July 27, 2018

**Re: Lindo Mexico Plaza
7112 Central Ave NE
Traffic Circulation Layout
Architect's Stamp 04-10-18 (K19-D151)**

Based upon the information provided in your submittal received 07-16-18, the above referenced plan cannot be approved for Building Permit until the following comments are addressed:

A-2

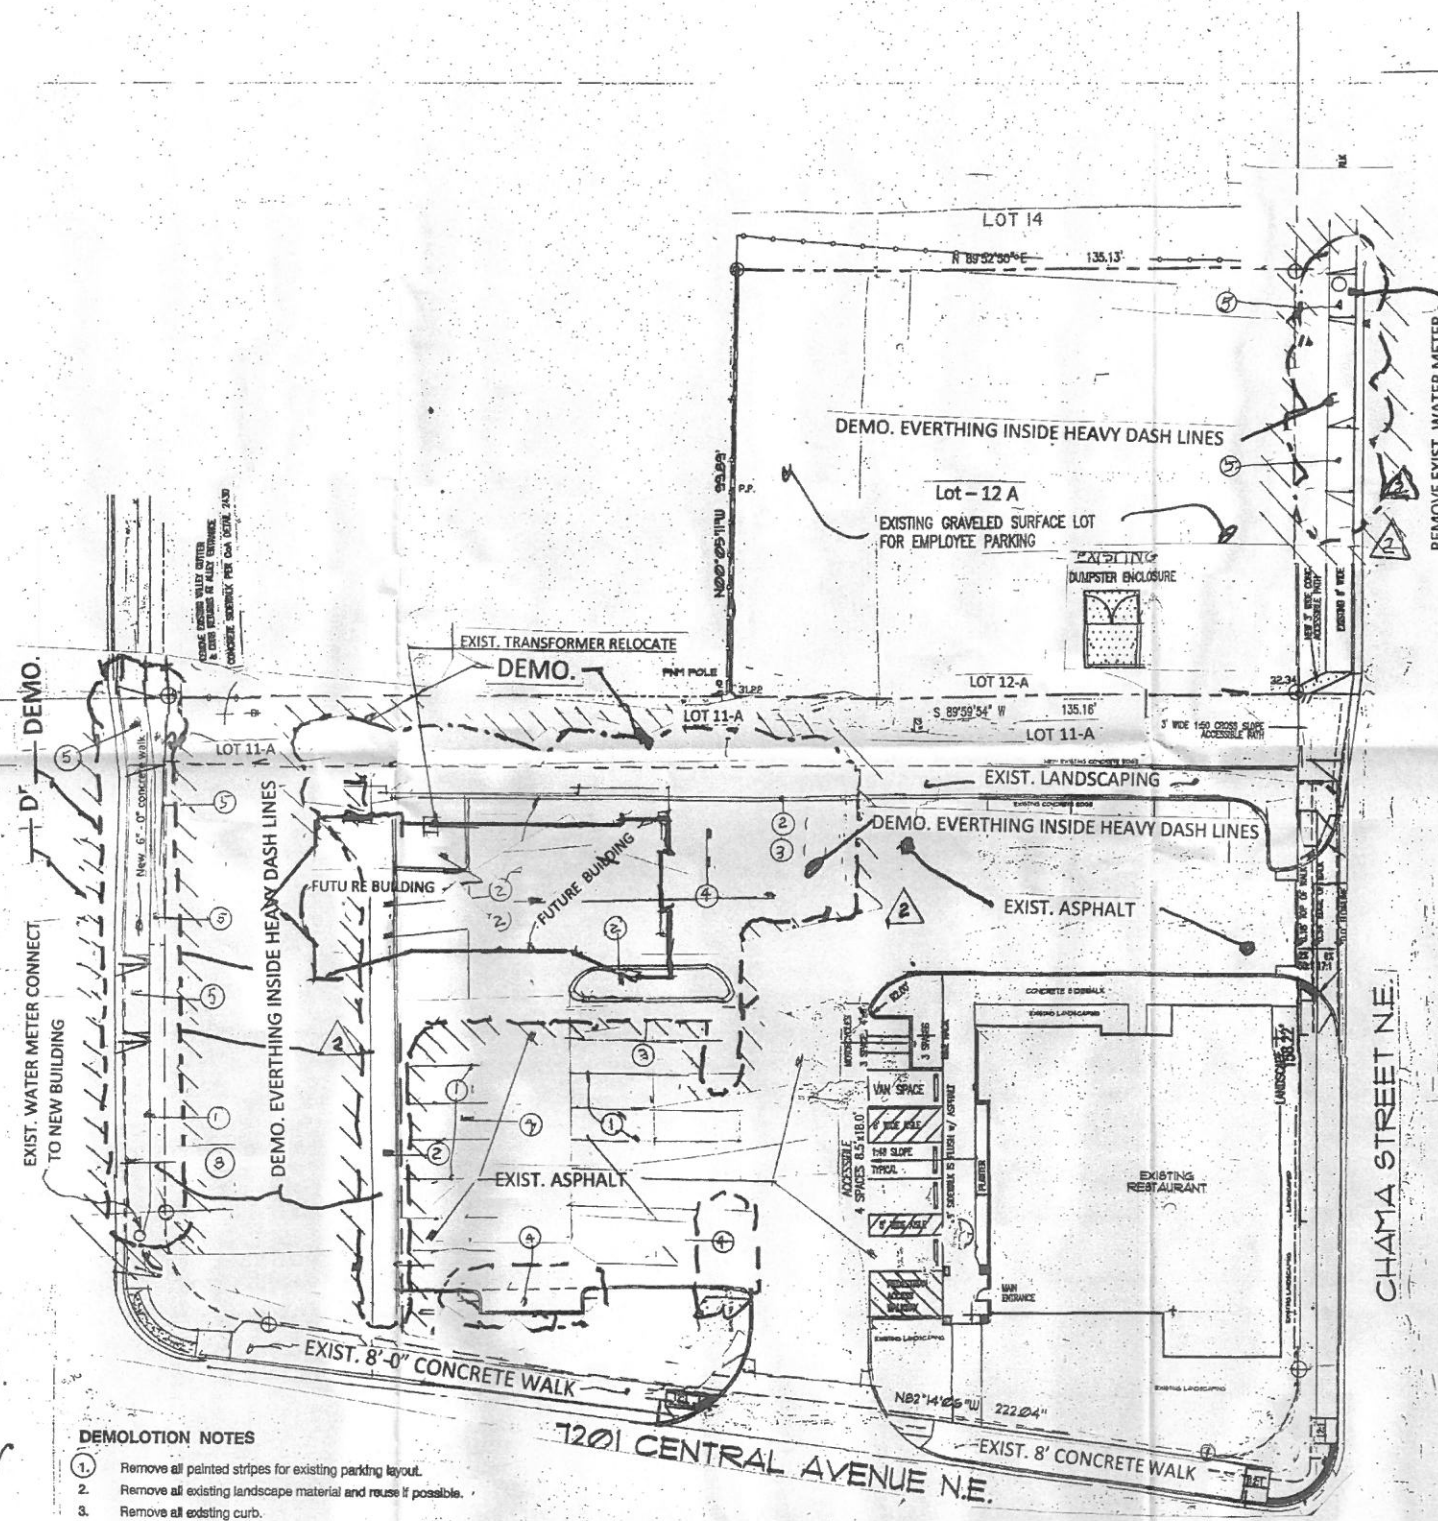
1. The 16 foot driveway on Chama St between the two entrances is not large enough for two way traffic and should be closed.
2. The demo plan boundaries and the new construction on the TCL are not matching up. The ADA parking sign should remain on the TCL plan.
